Improvement Permit

ISSUED TO: JBC Developers
PROPERTY LOCATION: 1115
SUBDIVISION: CREVIEW LOT # 208
Type of Structure: SFO-56x36 ZBR
Proposed Wastewater System Type: Pump to 25% Reduction system
Projected Daily Flow: 360 GPD
Number of bedrooms: 3 Number of Occupants: 6 max
Basement: No
Pump Required: No
Type of Water Supply: Public
Permit conditions: Meet on site for final layout maintain all x+BARK, keep drain lines with area shown for septic system keep drain line 10' from Septic Casement Line

Permit # 23553

# Harnett County Department of Public Health Site Sketch

**ROLLING STONE COURT
JBC DEVELOPERS, LLC.
THE MANCHESTER
LOT # 208 CRESTVIEW
SCALE: 1"=40'**

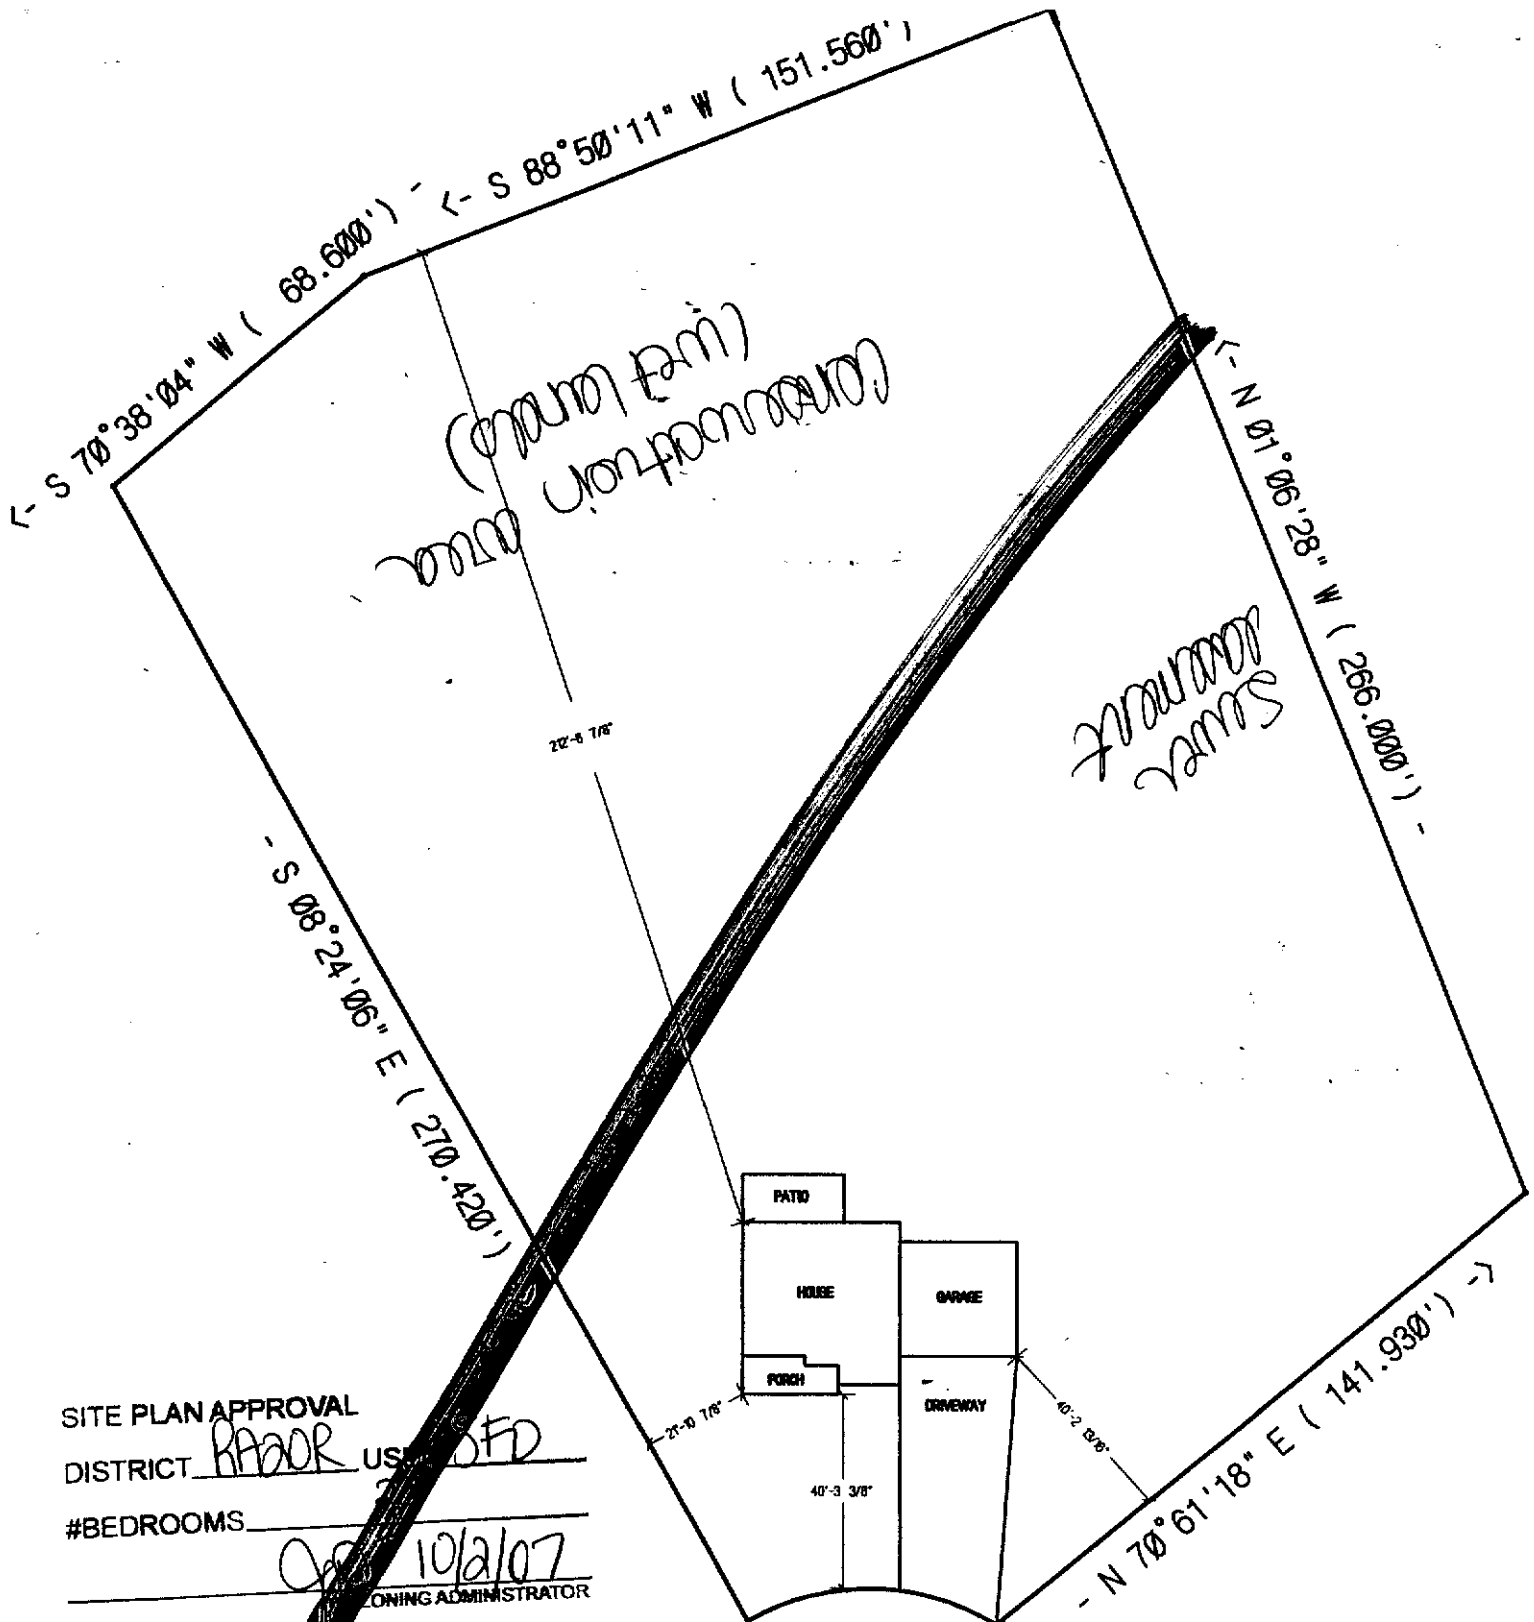
Meet onsite for Final Layout. Maintain all setbacks.  
Keep septic line within area marked. Install 1x25 of 25% Reduction System  
at 18" keep drain lines 10' from septic easement line
